MP 08_0045

Lake Macquarie Yacht Club Expansion
9 Ada Street
Belmont NSW

**RE: OBJECTION TO PROPOSED REDEVELOPMENT OF LAKE MAQUARIE YACHT CLUB
(08_0045)**

CLIENT: **LAKE MACQUARIE YACHT CLUB** DRAWING: **CLUBHOUSE NORTH & EAST ELEVATIONS**

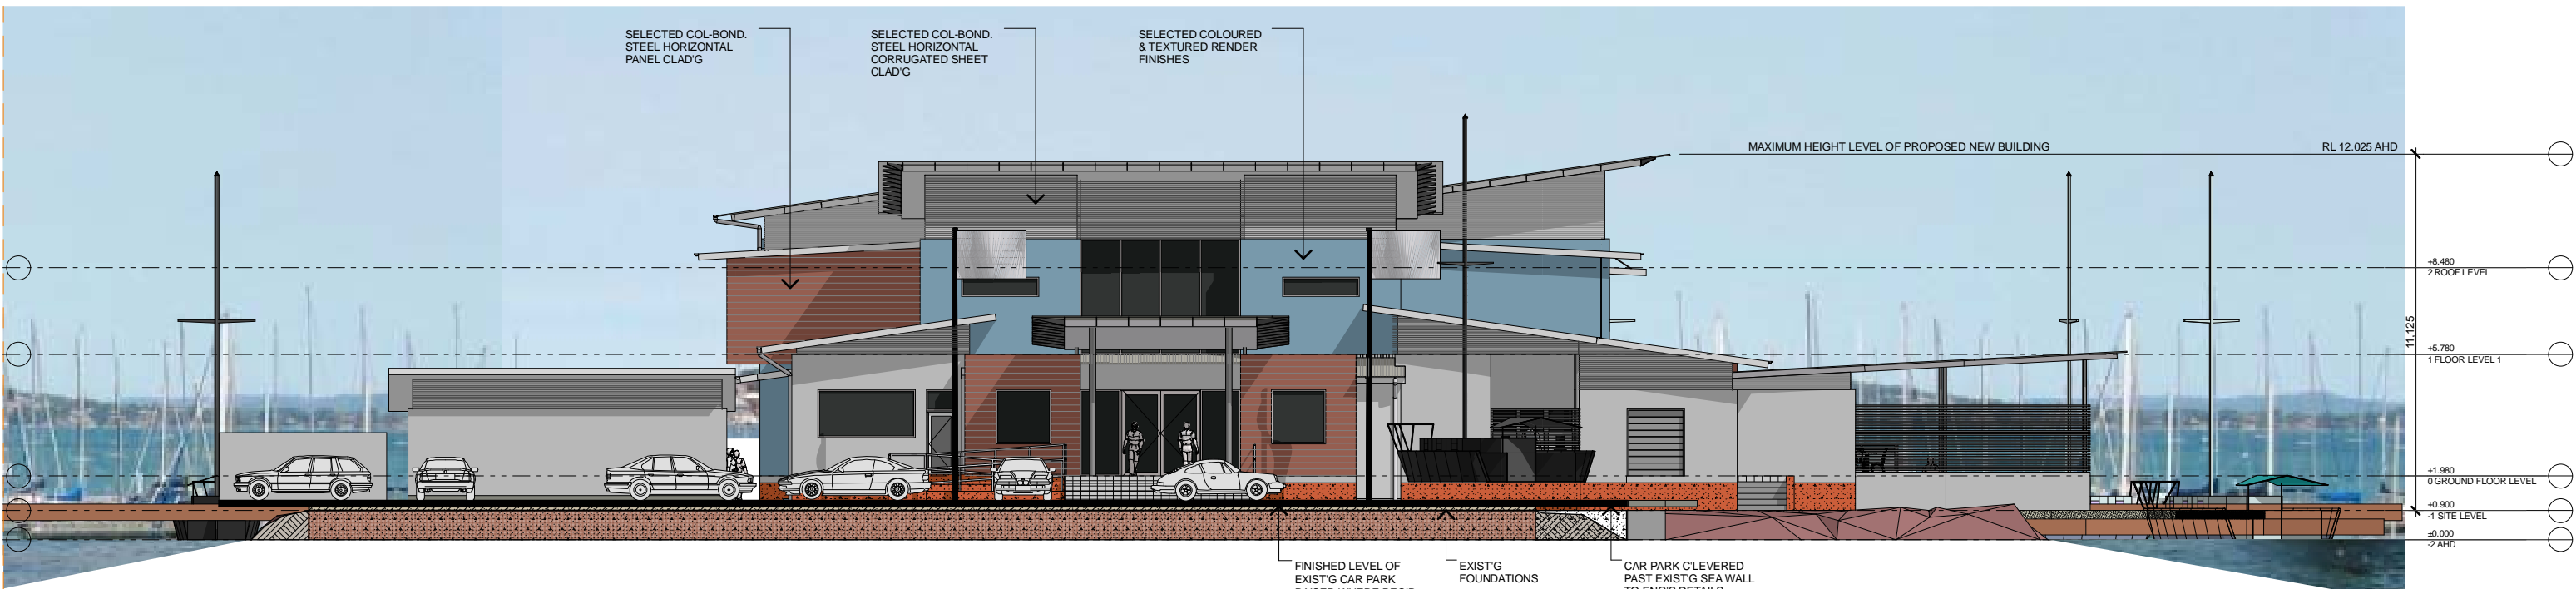
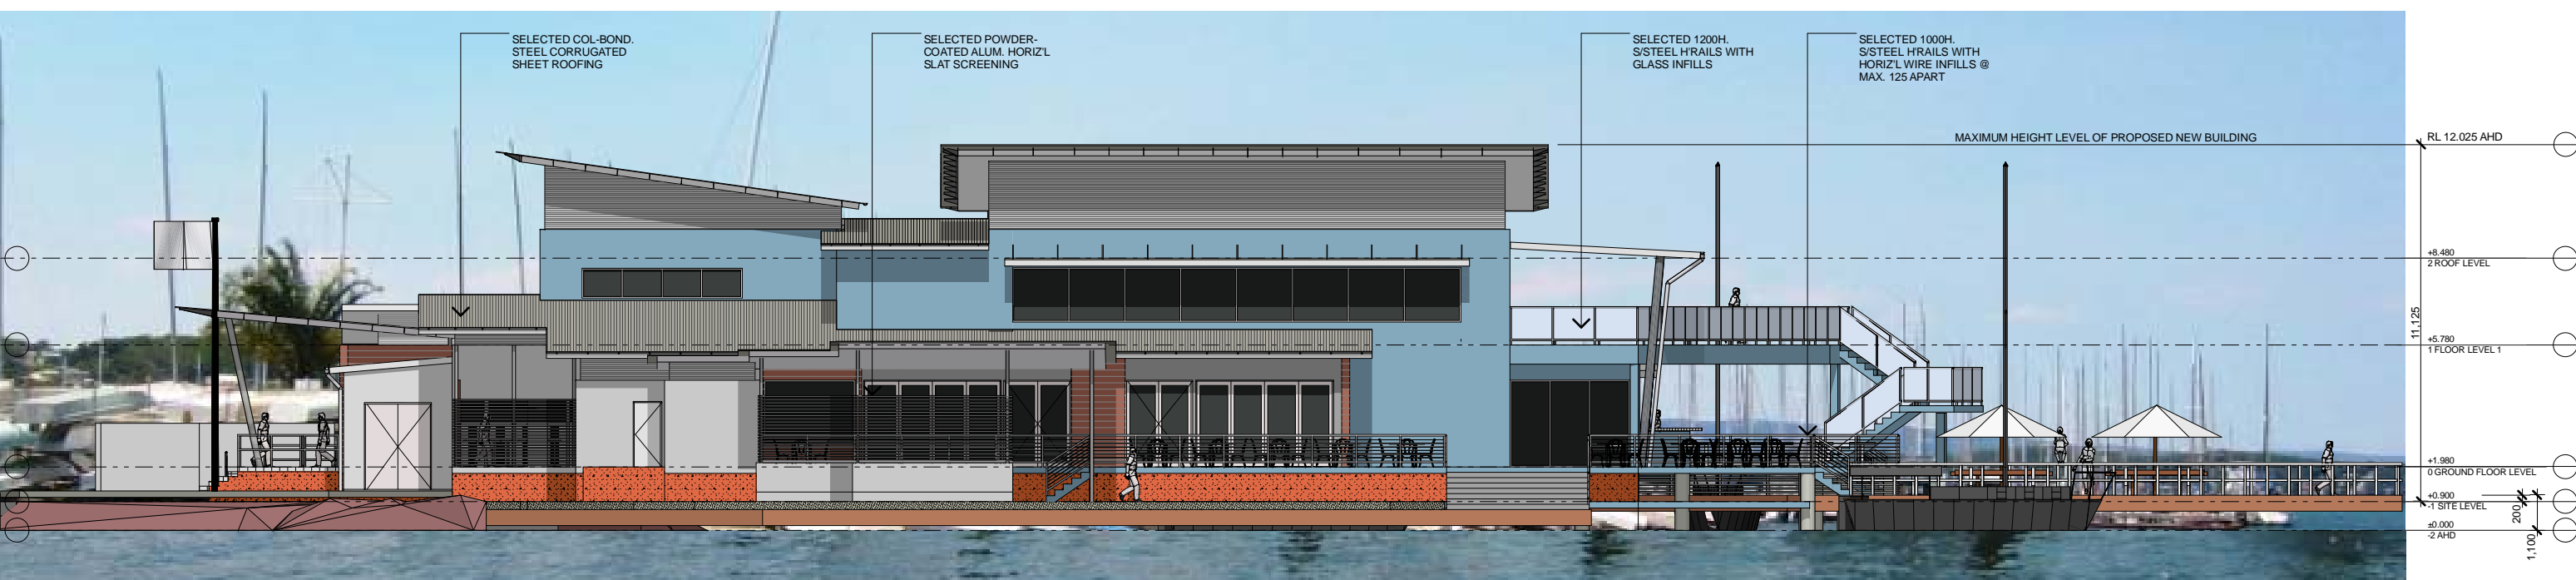
The proposed structure is significantly larger and bulkier than the existing structure (5 metres taller). It is proposed to raise the floor level of the building by 0.78m and the final height of the structure will be 12.025AHD (58% increase in height). The figures shown in "club house north and east elevations" prepared by EJE indicate the roof level of the 1st floor level roof line is 8.490 AHD. However, it appears that the roof area is excessively high with the final height of the roof at 3.5 metres above the first floor roof level. The area above the 1st floor roof level will be constructed of horizontal corrugated sheet cladding and unnecessarily obstruct views from the shore area and sensitive locations such as

7 Ada Street. The material while may be economic but is considered to be highly reflective and inappropriate for a structure in this highly sensitive location.

I would also question if there are any longer term plans to further develop the site in years to come. Given the bulk (3.5m) above the current first floor roof area it appears that there could be some long term plan to provide a 3rd storey to the building. If the proponent was serious about providing a club that is sympathetic with the surrounding environment rather than increasing the height of building by 5 metres. The design of the structure should be modified and the final height of the building restricted so that views are not unnecessarily blocked.
